From: David McRae
Sent: Monday, August 12, 2019 11:18 AM
To: 'William Roop'
Subject: RE: FW: Overhills Middle School Sign

I am in the process of reviewing the Overhills Middle School sign permit app.

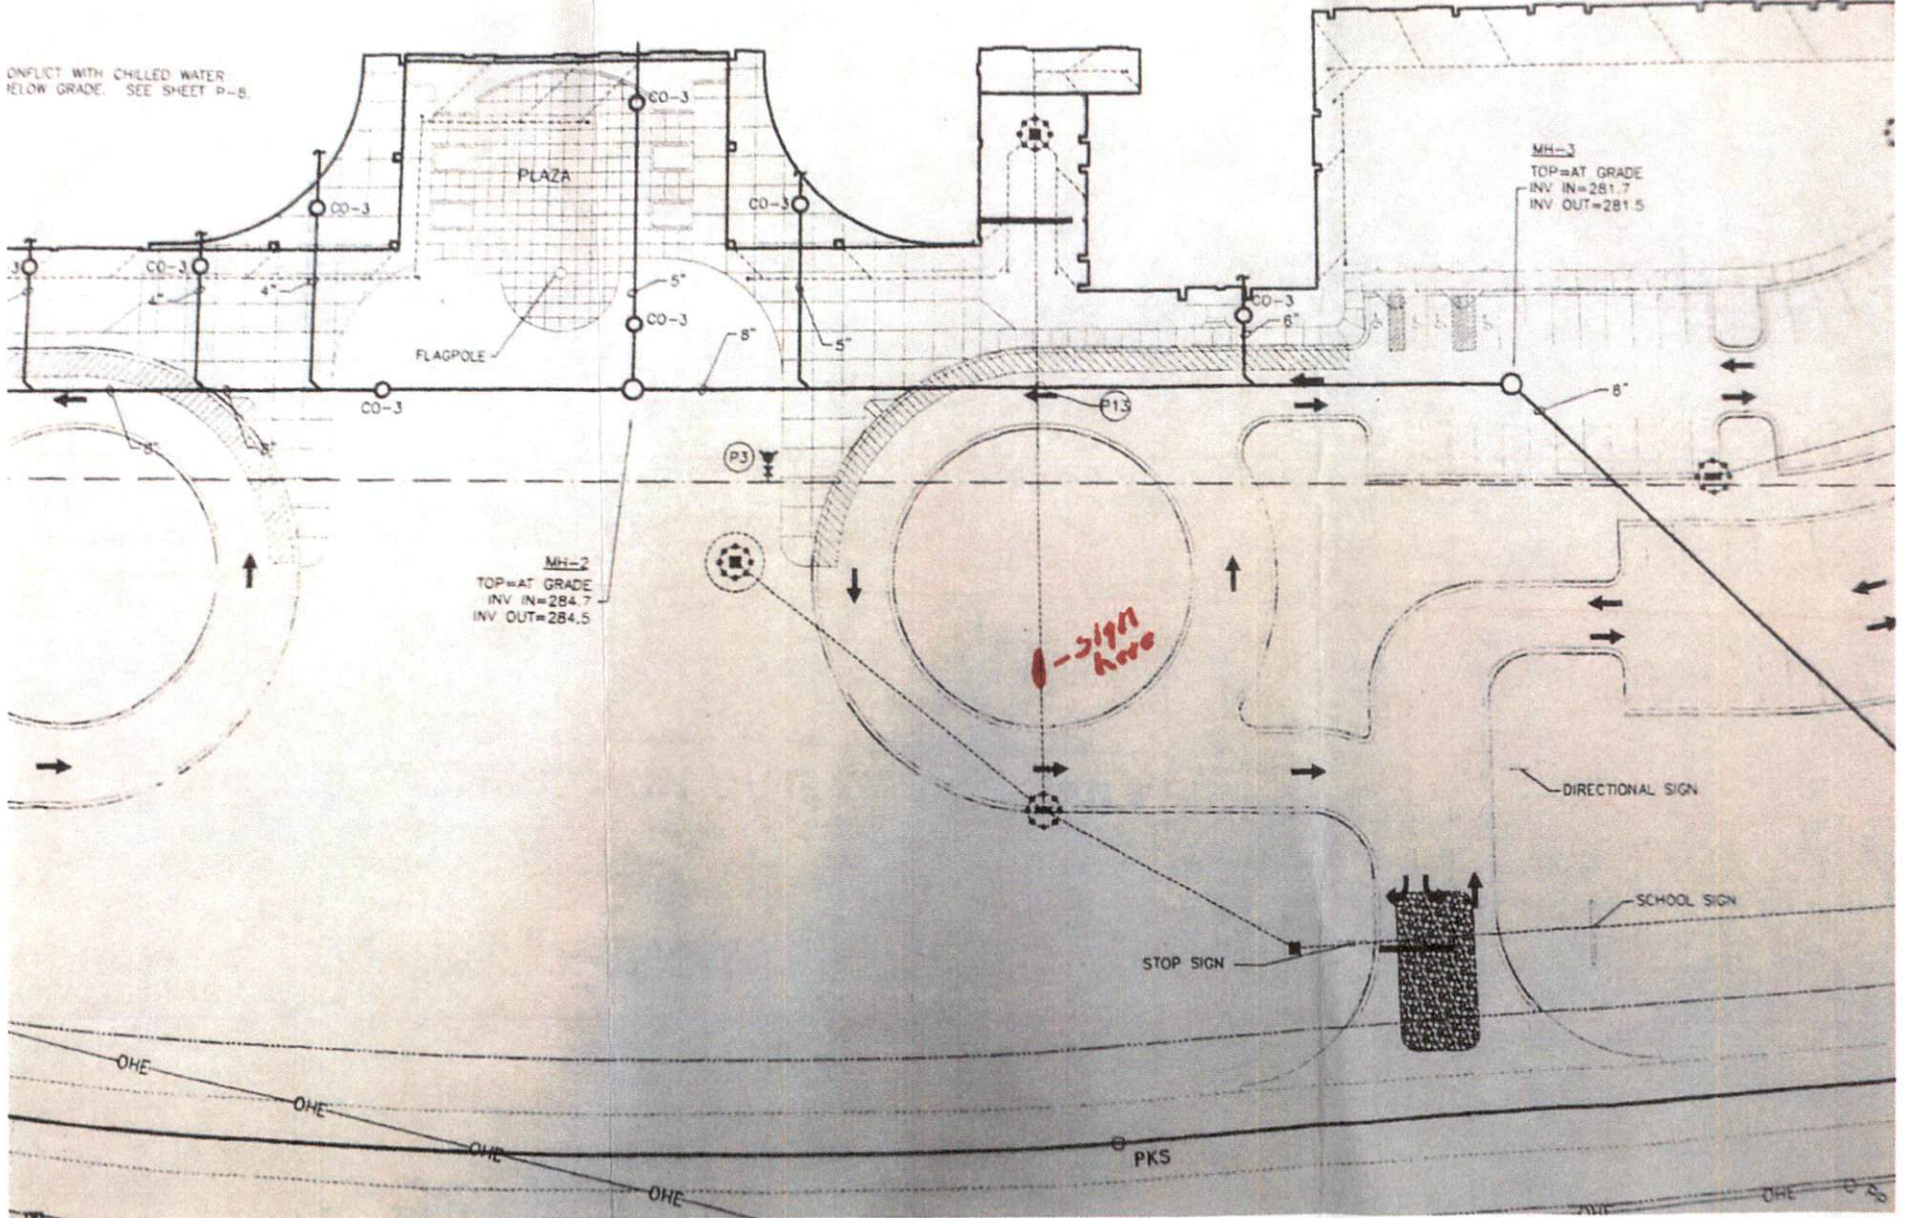
Based on my best available information (looking on google maps and streetview, I have not been out to the site) there appears to be two existing ground signs already on this parcel. Under the Harnett County UDO technically there is only a maximum of one (1) allowable ground sign for this site. But in speaking with the other staff there are a few options:

1. Upgrade one of the existing signs by adding the digital reader board portion to an existing sign will be fine. The "upfit" will still have to meet all other size requirements (total sq. footage and percentage of allowable digital reader board). Or,
2. Remove the concrete sign (pictured below) near the existing entrance and replace with the proposed sign (in the currently proposed location).
